Appeal Decision

Appeal Ref: APP/A2525/W/16/3163659

Rear of Tweenus, 17 Cobgate, Whaplode, Spalding, PE12 6TD

- The appeal is made under section 78 of the Town and Country Planning Act 1990 against a refusal to grant outline planning permission.
 - The appeal is made by Mr and Mrs R Fenwick against the decision of South Holland District Council.
 - The application Ref H23-0707-16, dated 18 July 2016, was refused by notice dated 13 September 2016.
 - The development proposed is a Residential Development (Single Building Plot).
-

LOCATION & SITE LAYOUT PLANS

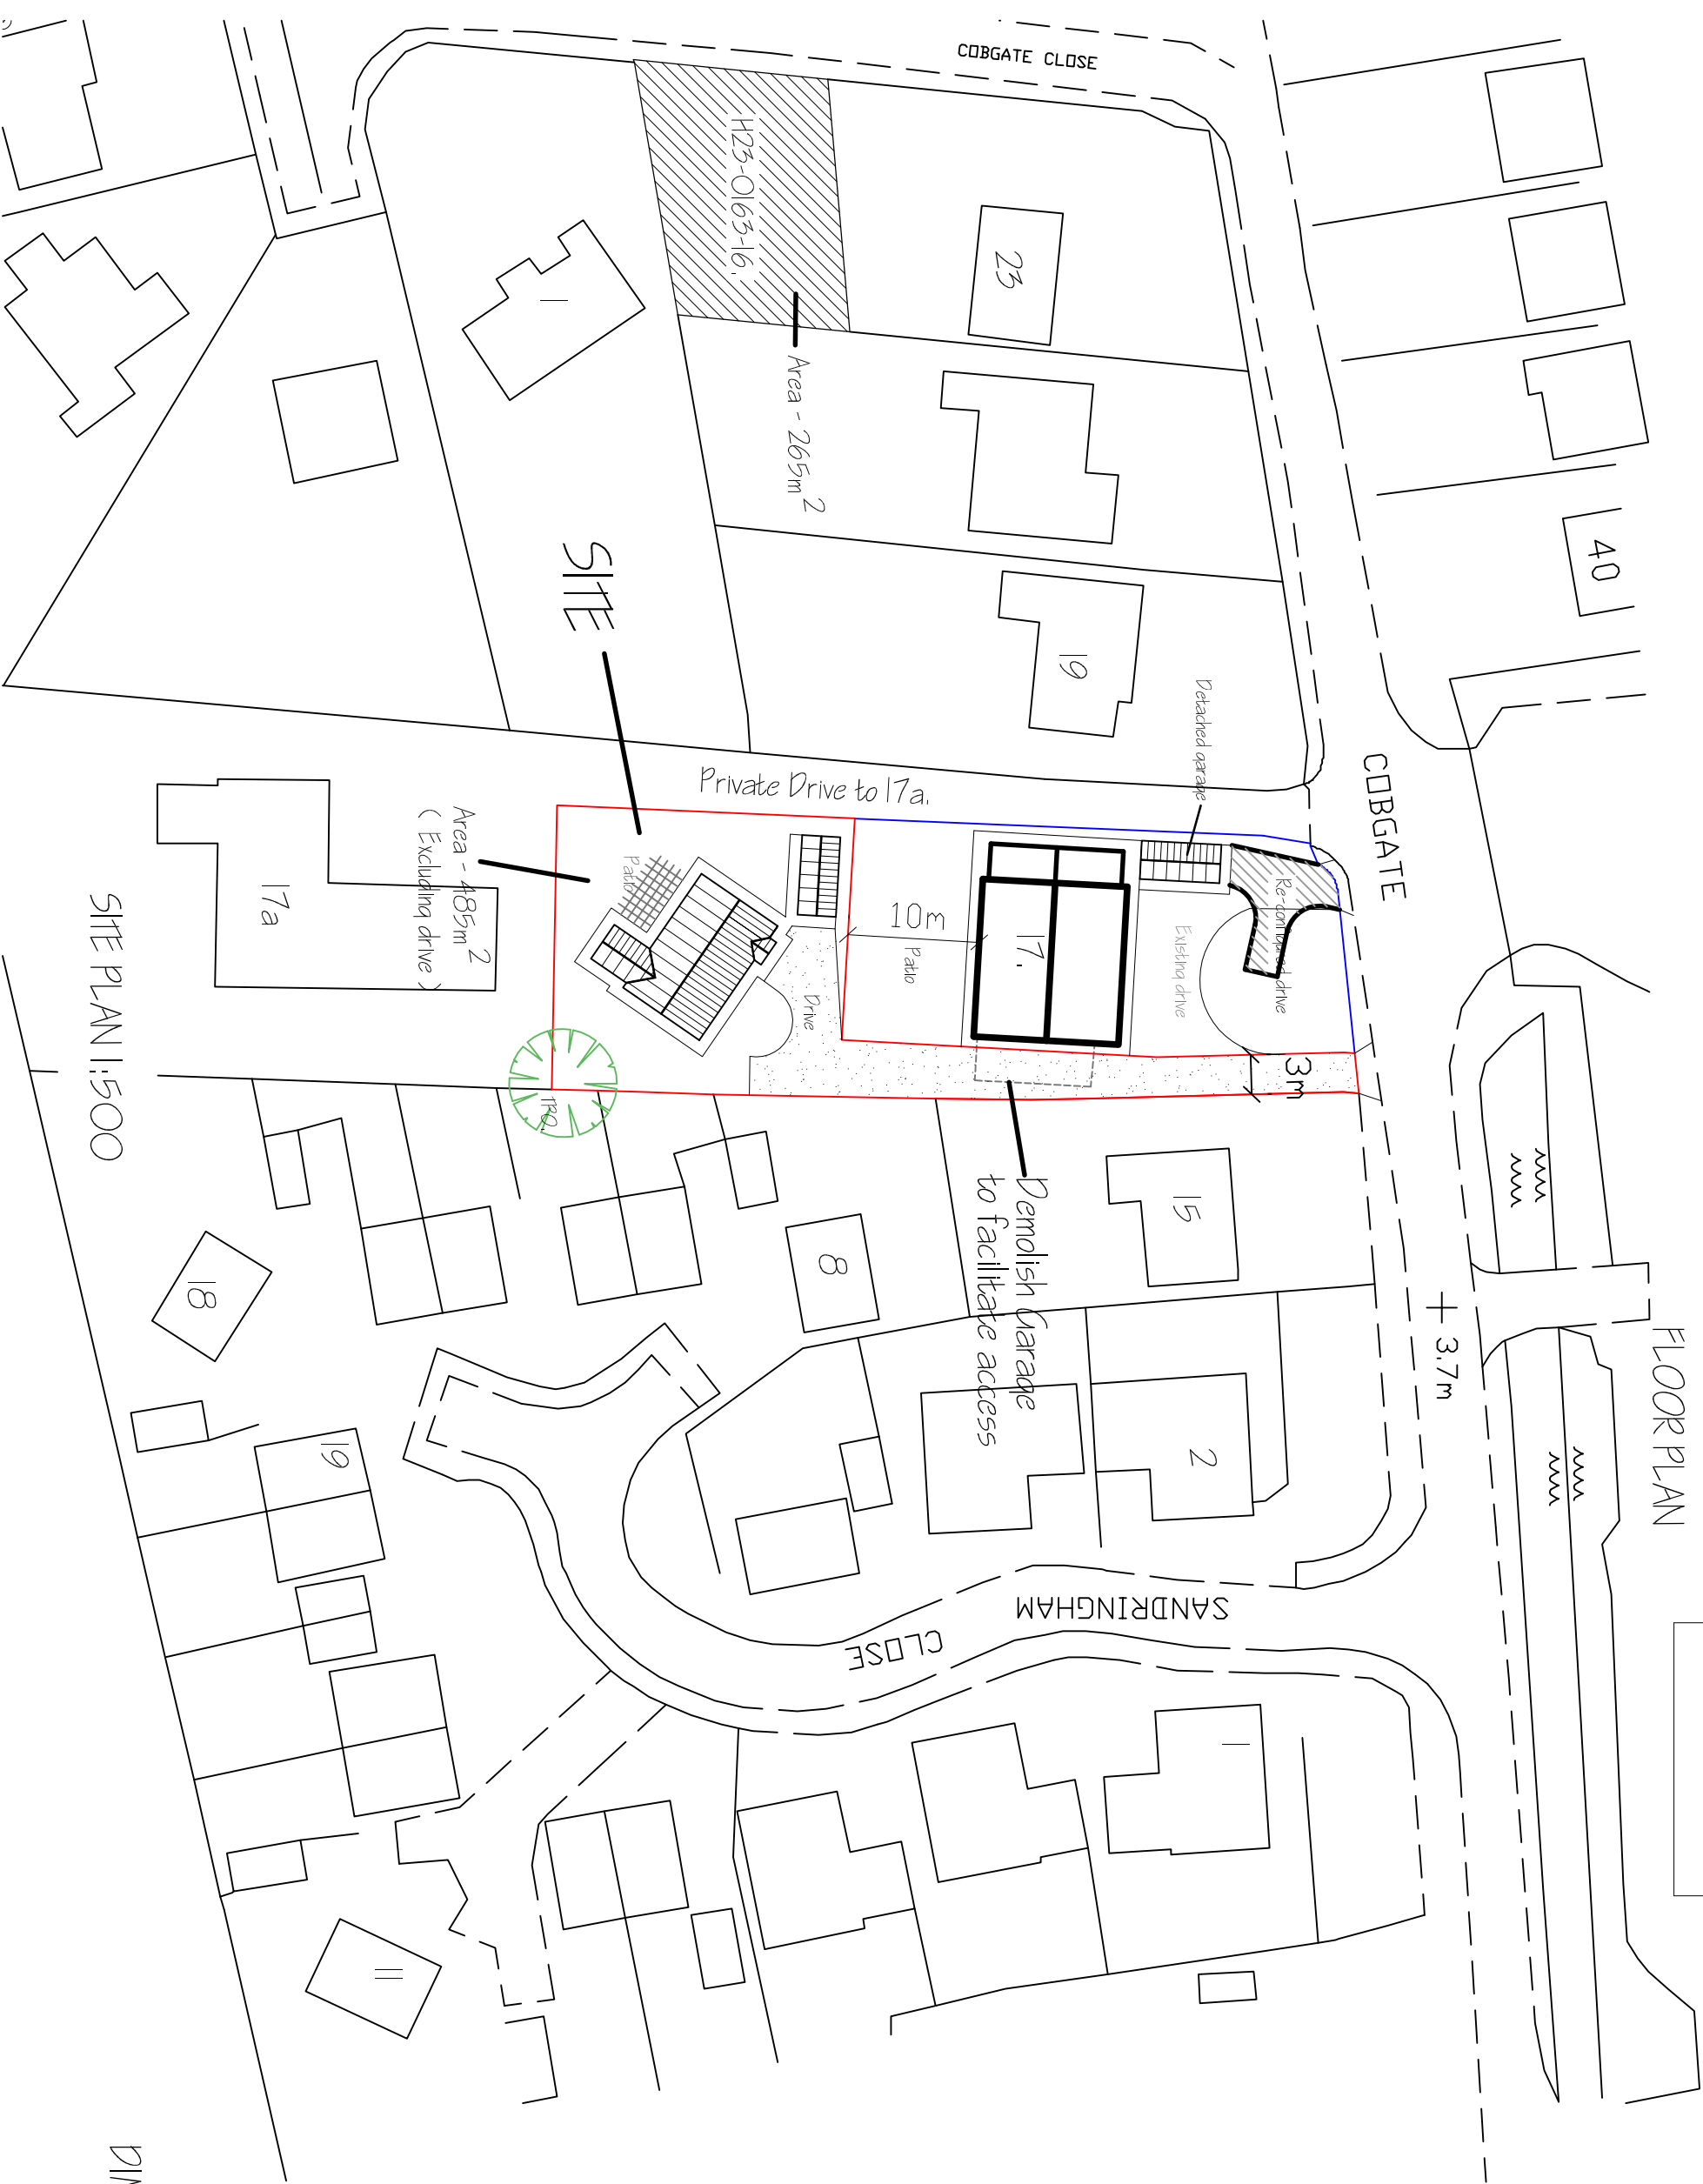
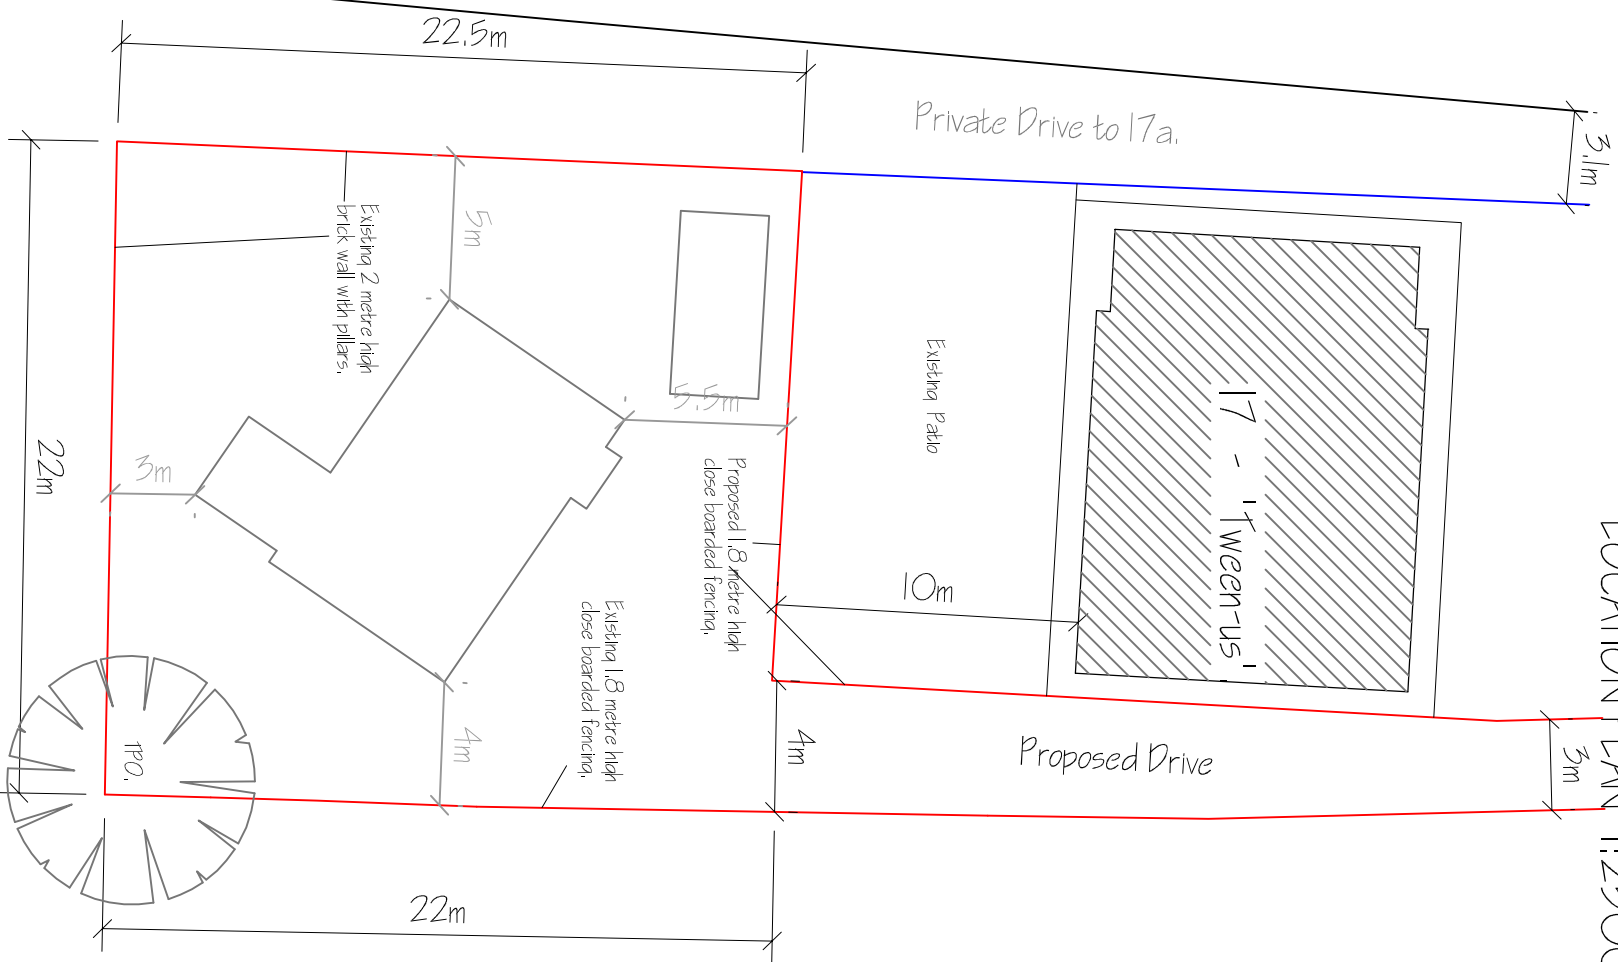
13. The plans show that the existing garage to the side of Tweenus would be demolished to form a vehicular access to the site. As a result, the vehicular access would extend in-between the flank elevations of Nos 15 and 17. The latter would be left with a blank flank elevation next to the access.

14. In terms of No 15, the flank elevation is, except for a single pane window, blank and set away from the boundary with Tweenus due to the driveway that leads to the detached garage. The main windows in No 15 are to the front and rear. Tweenus also has large window openings to the front and rear. The latter serves as the main bedroom and has a rear outlook.

15. Vehicles entering and leaving the appeal site would lead to noise and disturbance. The material effect of this would be felt by the occupants of No 17 rather than No 15, who would remain a reasonable distance away. The detached garage of No 15 would also help shield rear facing windows in this property. I am also mindful of the current use of the driveway which leads to the garage and across the front elevation of Tweenus and any noise and disturbance would be typical of a single dwelling in the area. Furthermore, the appellants' suggest that a new 2 metre high boundary fence could be erected next to the access. I note the Council's suggested condition regarding details of boundary treatments which has the potential to mitigate for any effects of vehicle movements felt within the rear bedroom in No 17. So, while noise and disturbance would arise due to the site's constraints, this would not cause a material harm to the living conditions of Nos 15 and 17.

- 2) The development hereby permitted shall be carried out in accordance with the following approved plans: 2980-16-01, except in respect of the detached garage and re-configured drive shown on this plan.
